FLRD #2, LLC.

PHASE II REGIONAL WATER IMPROVEMENTS

0.26 MG POTABLE WATER TANK

LANDSCAPE ALTERNATIVE – EXHIBIT A

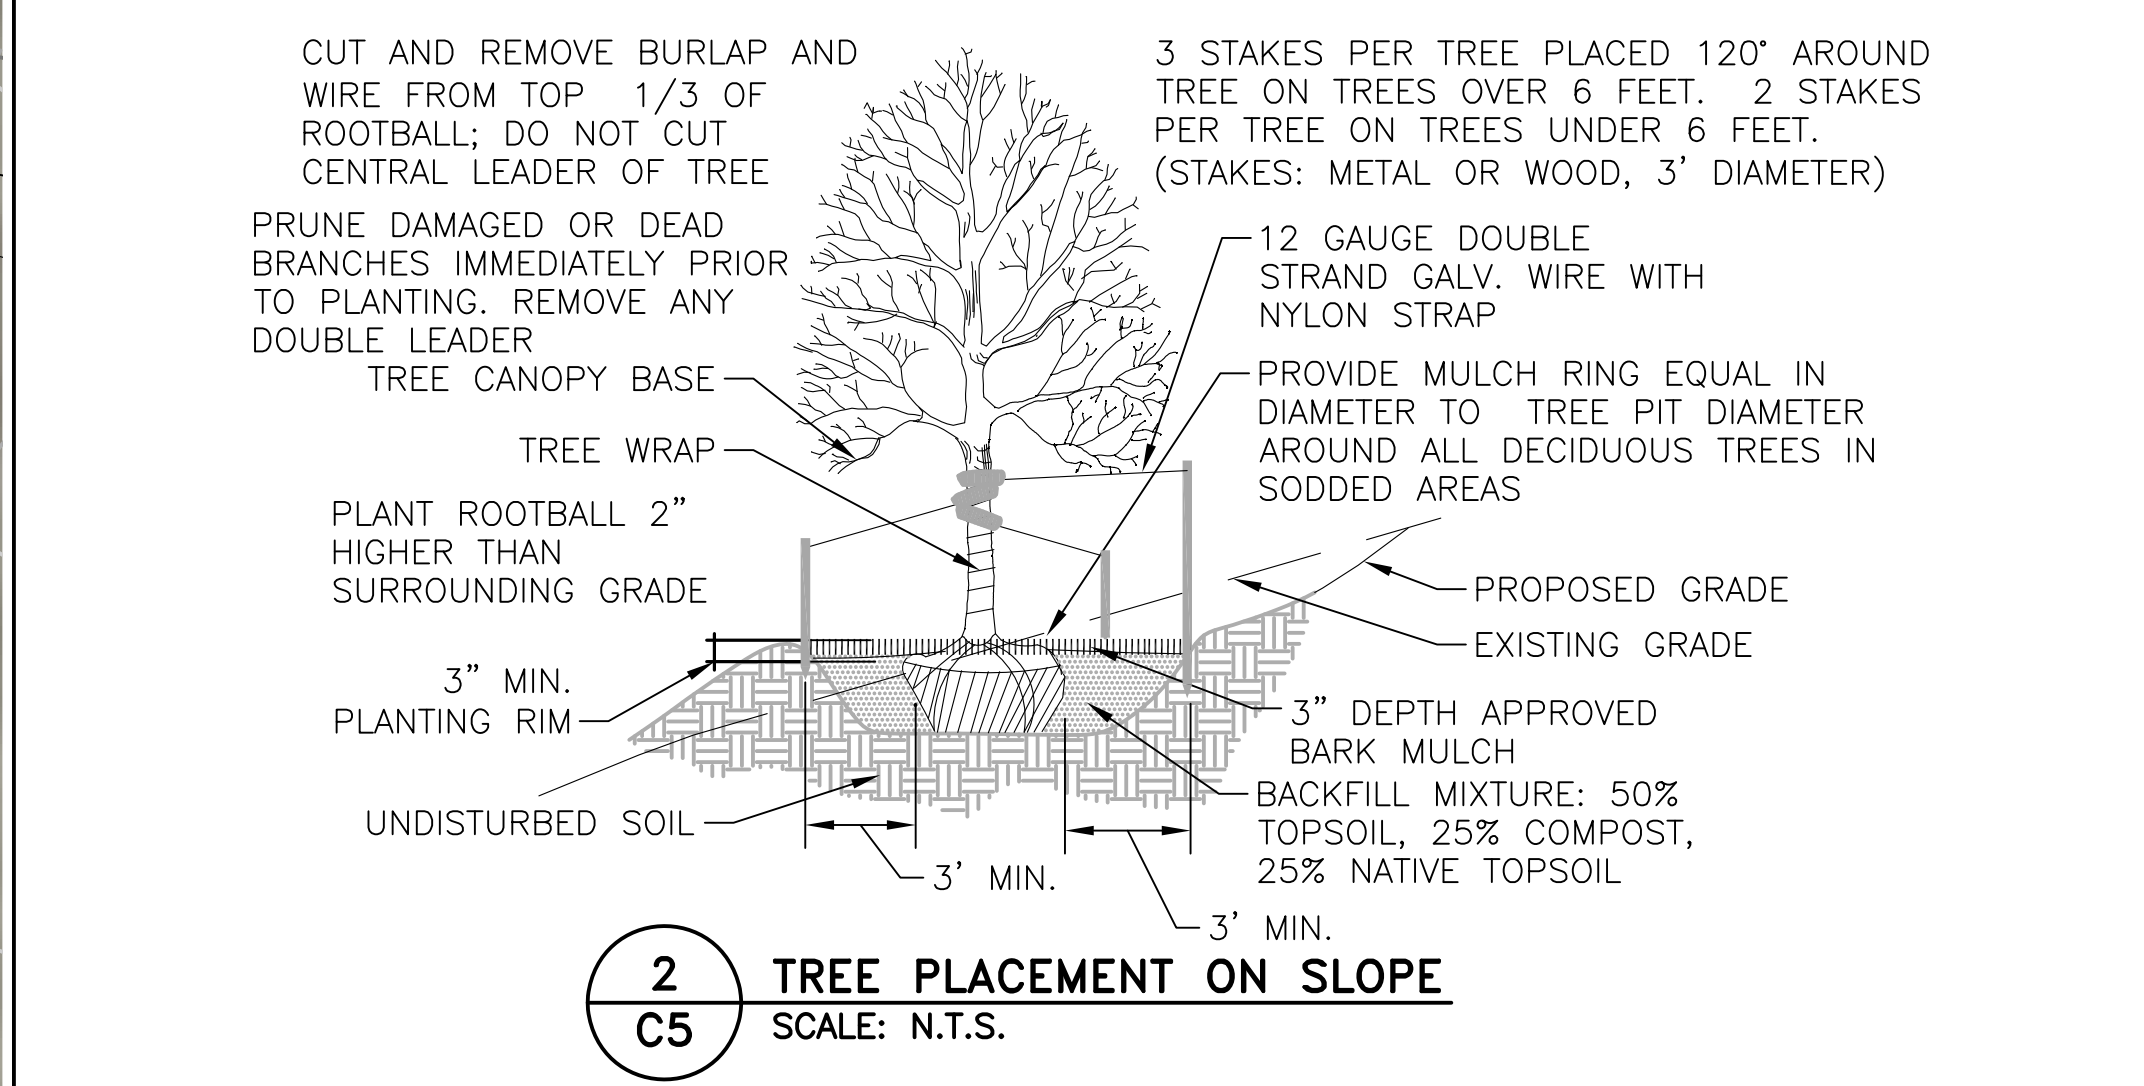
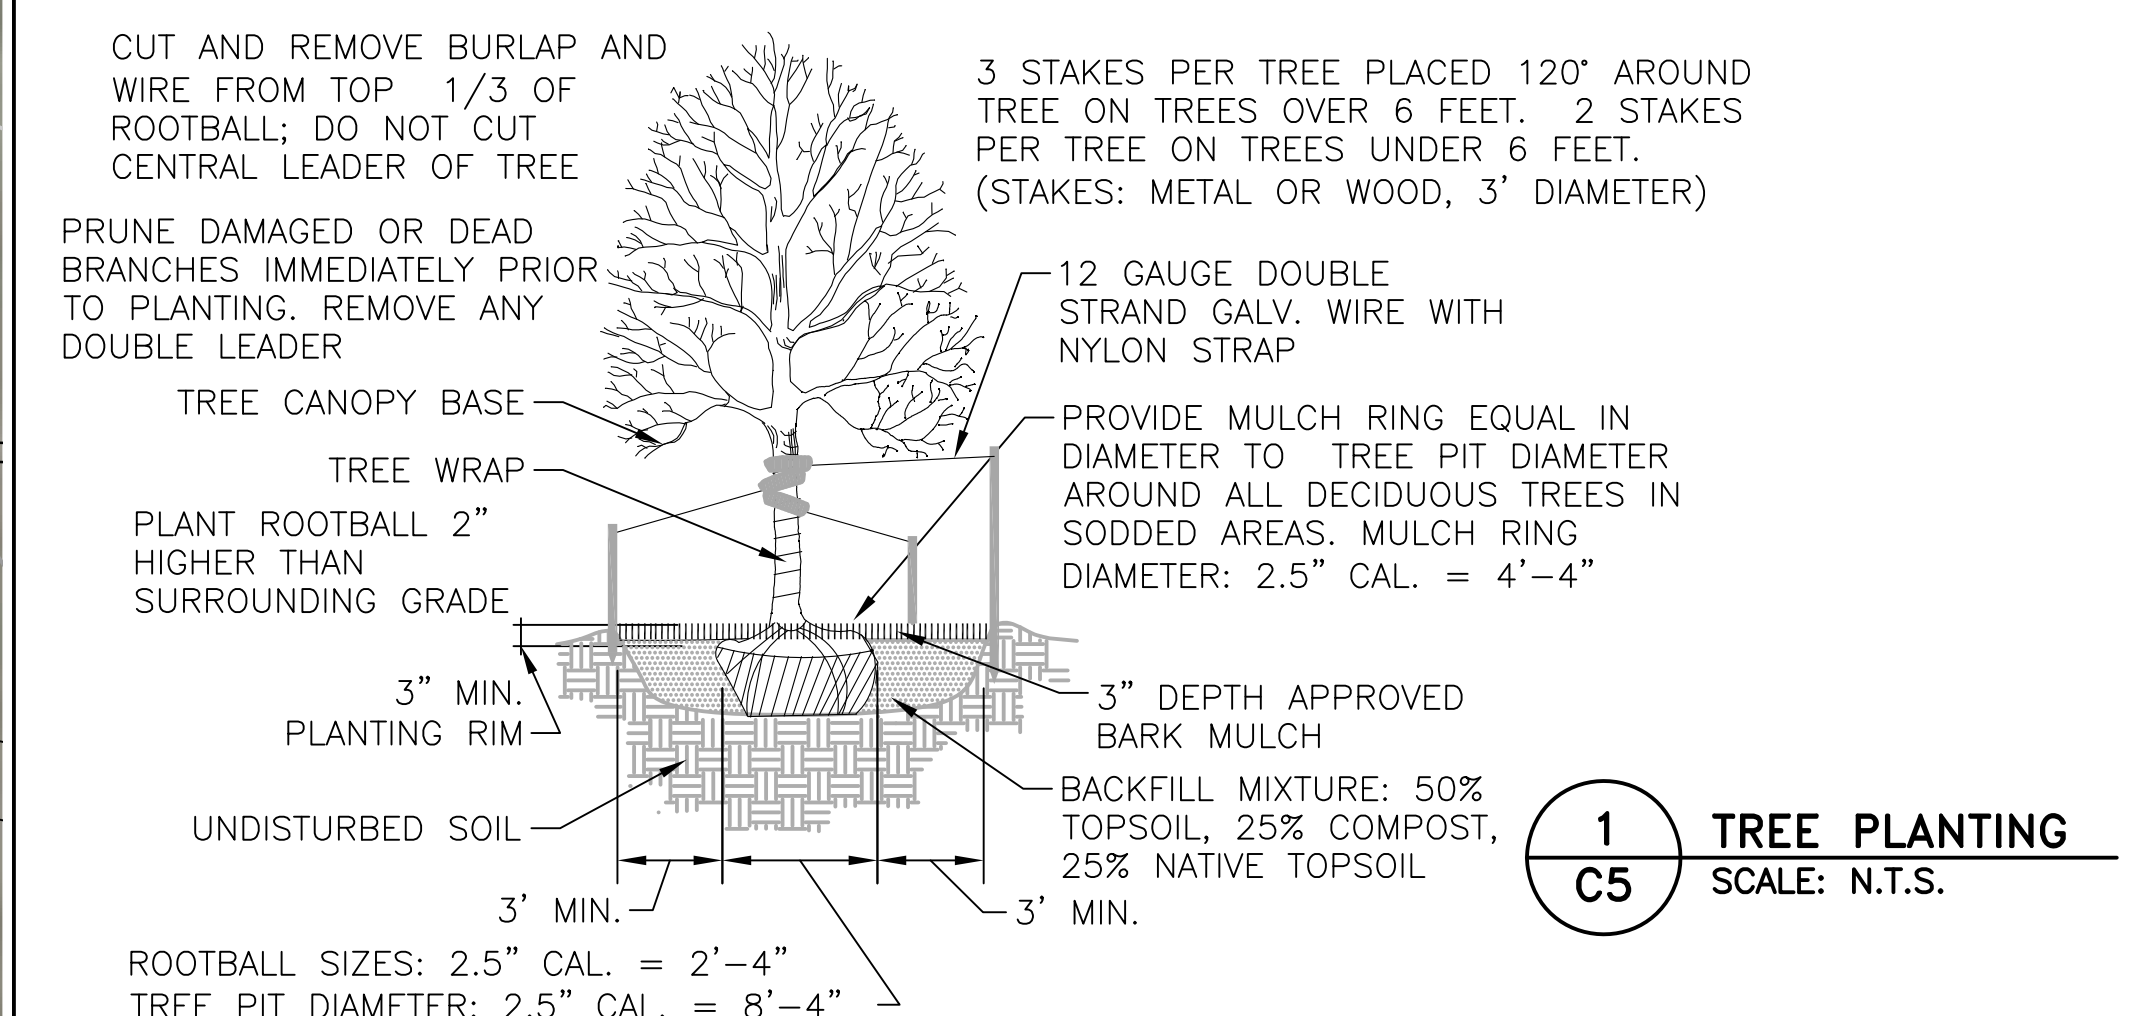
show an inset of 6.5 acre tract and the larger property

entire 6.5 acre tract needs to be on here

use latest layout recored with PUDSP196

fix the scale so its electronically accurate

the planset is specific to the tract the tank site lies on- include the details and remove the notes that defer details

you have to meet the basic landsape plan: fence details per the PUDSP (6' perimter and split rail fence, trail, provide seed mix and location of mix.... There was discussion of evergreen trees at some point- show existing vegetation to be saved and fenced off during construction by injecting an aerial with clouded areas of preservation on the plan in lieu of drawing each symbol...

superimpose 6.5 acre tract and tank, fences, asphalt etc....
